# Officers Report

Tel: 01895250320  
Case Officer: Maria Tomalova  
Email: mtomalova@hillingsdon.gov.uk  
Date: 25th January 2018

RE: Double storey side extension and conversion into 2 self contained units.

SITE: 97 North Hyde Road Hayes

| Rev. No. | Description | Date | Project:    | Single storey rear extensions, double storey side extension & conversion of dwelling into 2 dwellings<br>97, North Hyde Road, Hayes, UB3 4NP |
|----------|-------------|------|-------------|----------------------------------------------------------------------------------------------------------------------------------------------|
|          |             |      | Drg No:     | A-302                                                                                                                                        |

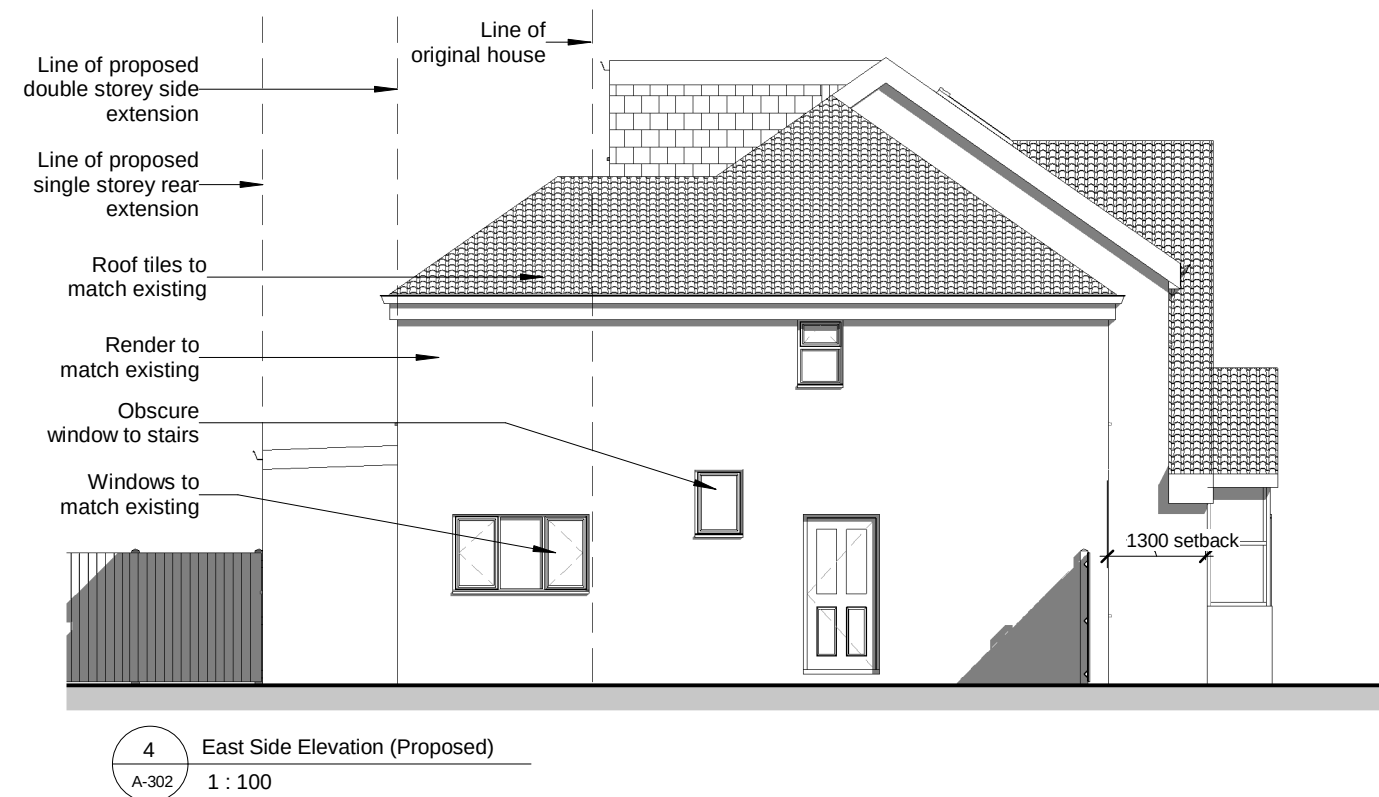
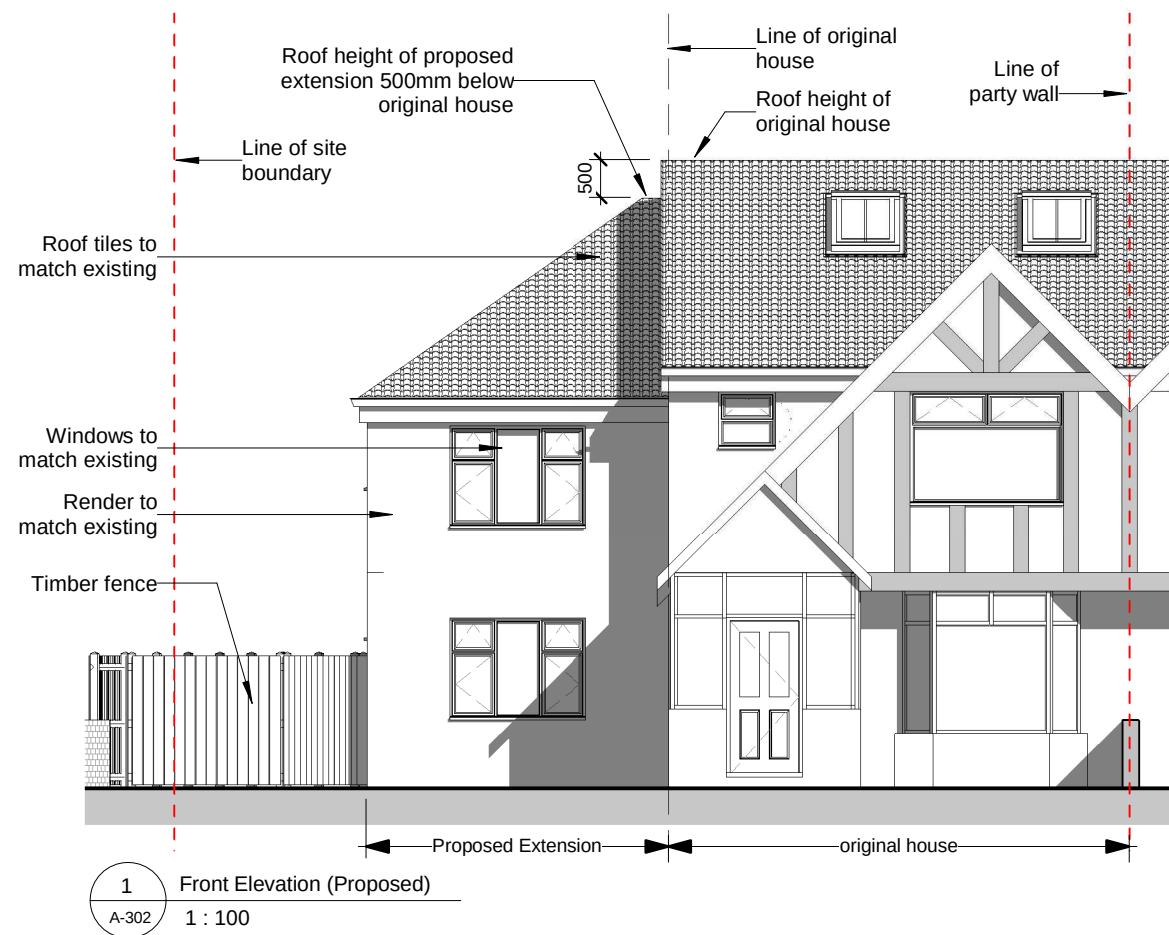
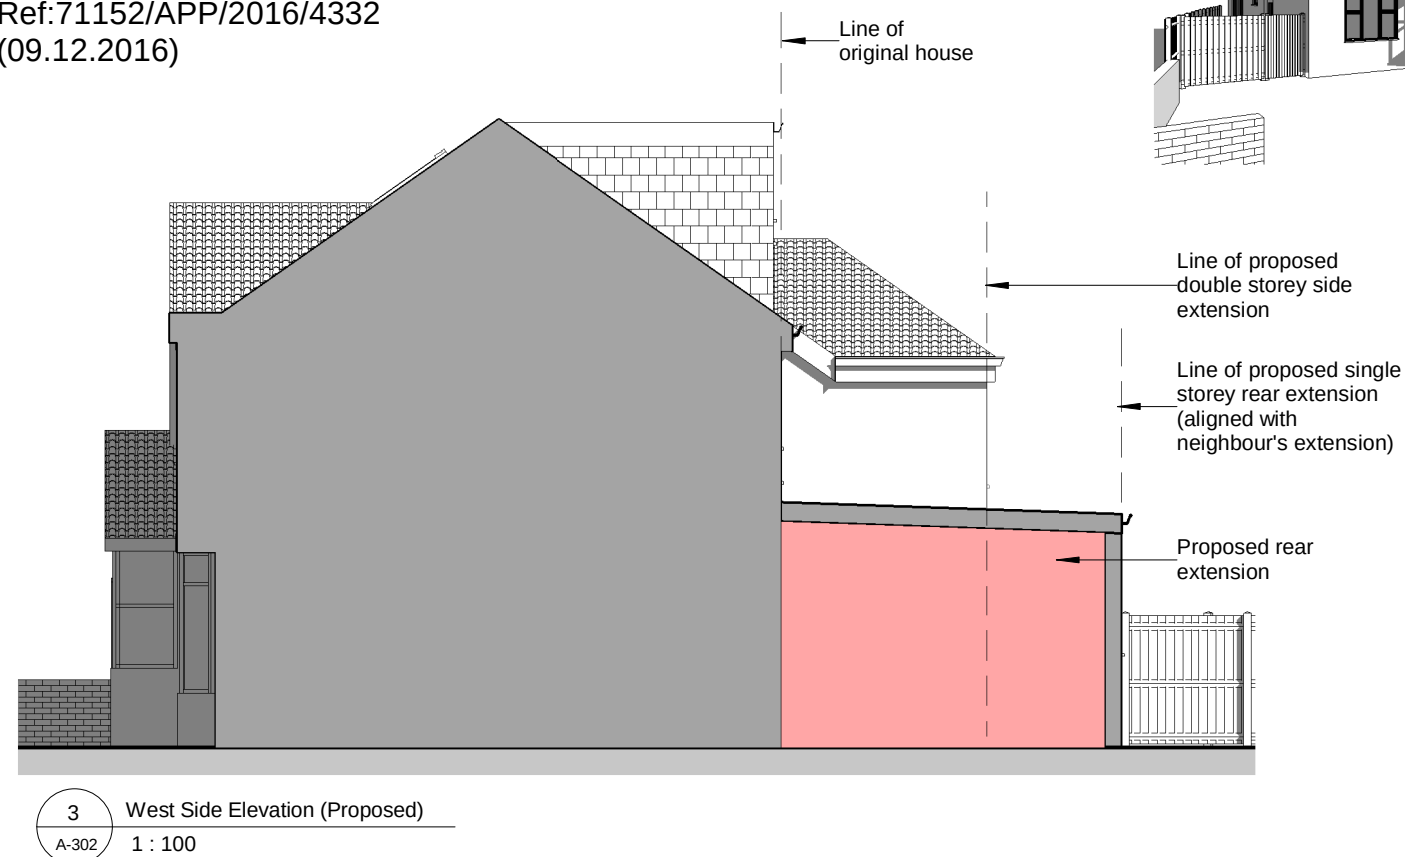
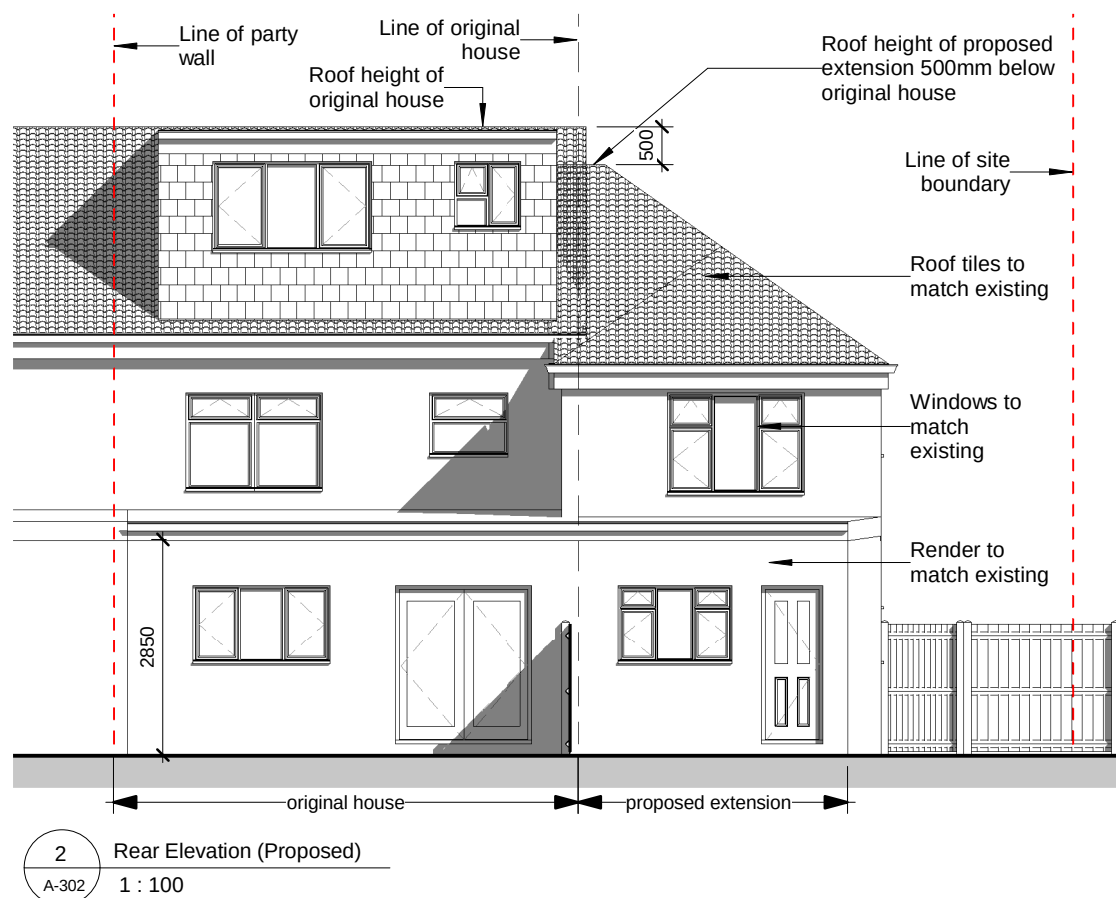
The proposed two storey side extension would be characterised by a hipped roof measuring a maximum height of 7.65 m which would be lowered by 0.5 m at roof level and therefore would comply with the height for two storey extensions, as specified in paragraph 5.8 of the HDAS SPD. The 4 m wide side extension would be almost two thirds of the main house (6.12 m) and therefore complies with the HDAS SPD as specified in paragraph 5.10. However, the proposed two storey side extension would be extending the semi-detached property already extended to the roof involving a hip to gable and a large rear dormer. Therefore the proposed extension would result in a more substantial unbalancing of this pair of semi-detached dwellings.

The proposed first floor rear extension would have a flat roof above, which is not acceptable. As mentioned above, any two storey extension to a house with a pitched roof should also have a pitched roof and a flat roofed extension will not generally be accepted. Therefore, the proposed first floor rear extension with a flat roof above due to the existing large rear dormer and those two extensions would not complement each other but on the contrary would result in a poor design, and are therefore not acceptable as mentioned in section 6.0 of the HDAS SPD. The proposed first floor extension therefore would impact unduly on the character and appearance of the existing and adjoining properties and the visual amenities of the area in general.

One large window and entrance door would be inserted on the front elevation at ground level and one window at the first floor level. The same fenestration is proposed at the rear elevation of the proposed side extension. One larger casement window and one small high level window would be inserted on the side elevation at the ground floor level and one small, non openable up to 1.7 m at the first floor level. It is considered that proposed entrance door at the front elevation of the proposed side extension should be removed and replaced on the side elevation facing to No 99 North Hyde Road.

The proposed two storey side extension due to its position at the semi-detached dwelling as an addition to an already extended property, and the first floor extension, due to its roof form in connection with an existing large rear dormer, would be an

incongruous addition to the original dwelling, and would be damaging to the architectural composition of the property and the visual amenities of the area. Therefore, the development is considered unacceptable.
